**From:** Mau, Russell E (DOH) [<mailto:Russell.Mau@DOH.WA.GOV>]  
**Sent:** Wednesday, May 18, 2016 11:02 AM  
**To:** Jeff Watson  
**Cc:** Holly Duncan; Holly Myers; Serr, Ben A (DOH)  
**Subject:** RE: Notice of Application: SP-16-00001 Mitchell

## Subdivision PH Comments

RE: SP-16-0001 Mitchell

**MITCHELL SHORT PLAT
PART OF SECTION 31, T. 20 N., R. 17 E., W.M.
KITITIAS COUNTY, WASHINGTON**

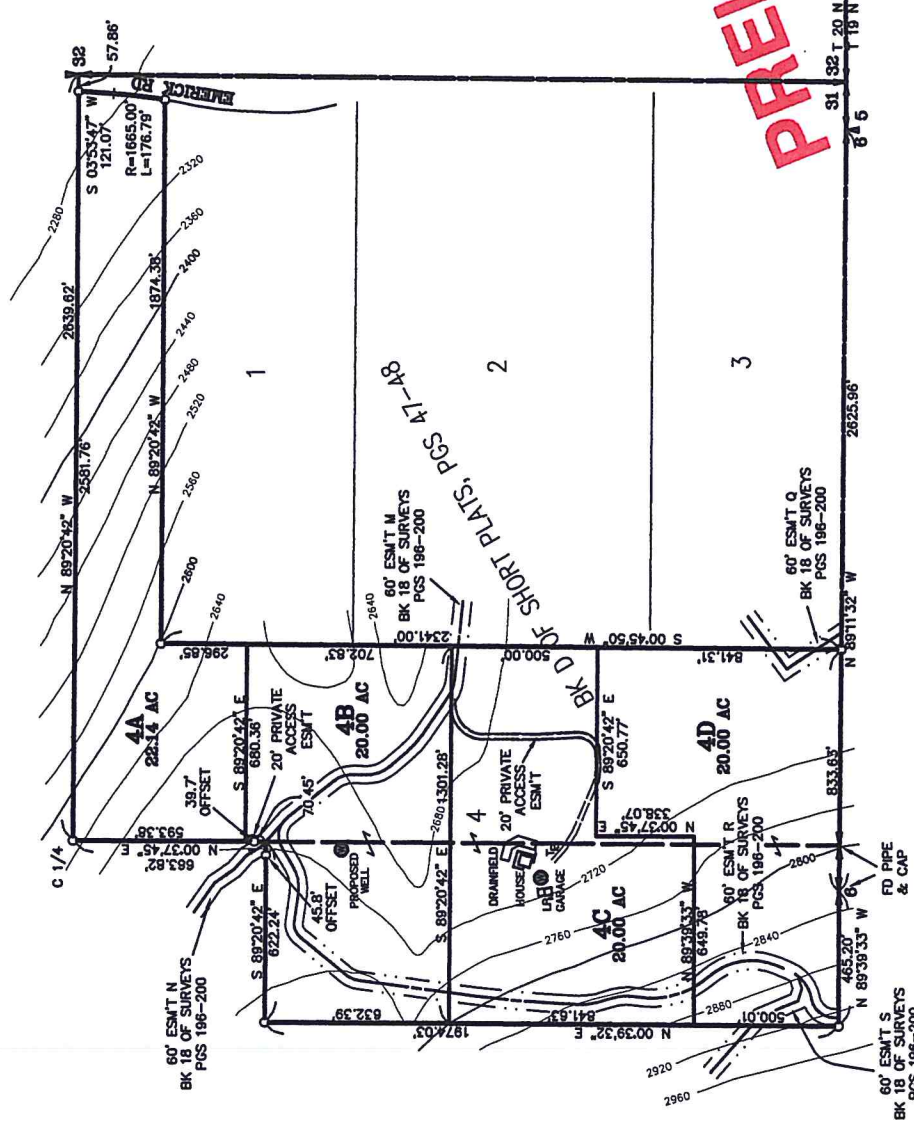
Specific Conditions: Prior to final plat approval, the group B system must be installed and include proof of water mitigation for all 4 lots within this plat.

Well location. The drawings shall be marked with a "w" indicating location of the well and a broken line showing the one hundred foot radius around such.

All wells must meet the distance requirement of 50 feet from the property line, 50 feet from the septic tank and 100 feet from the drain field as per Kittitas County Critical Areas Ordinance 17A.08.25, and KCC Chapter 13. If existing wells do not meet the setback requirement from property lines, the two adjoining parcels nearest the well must enter into a legal, shared well-users agreement.
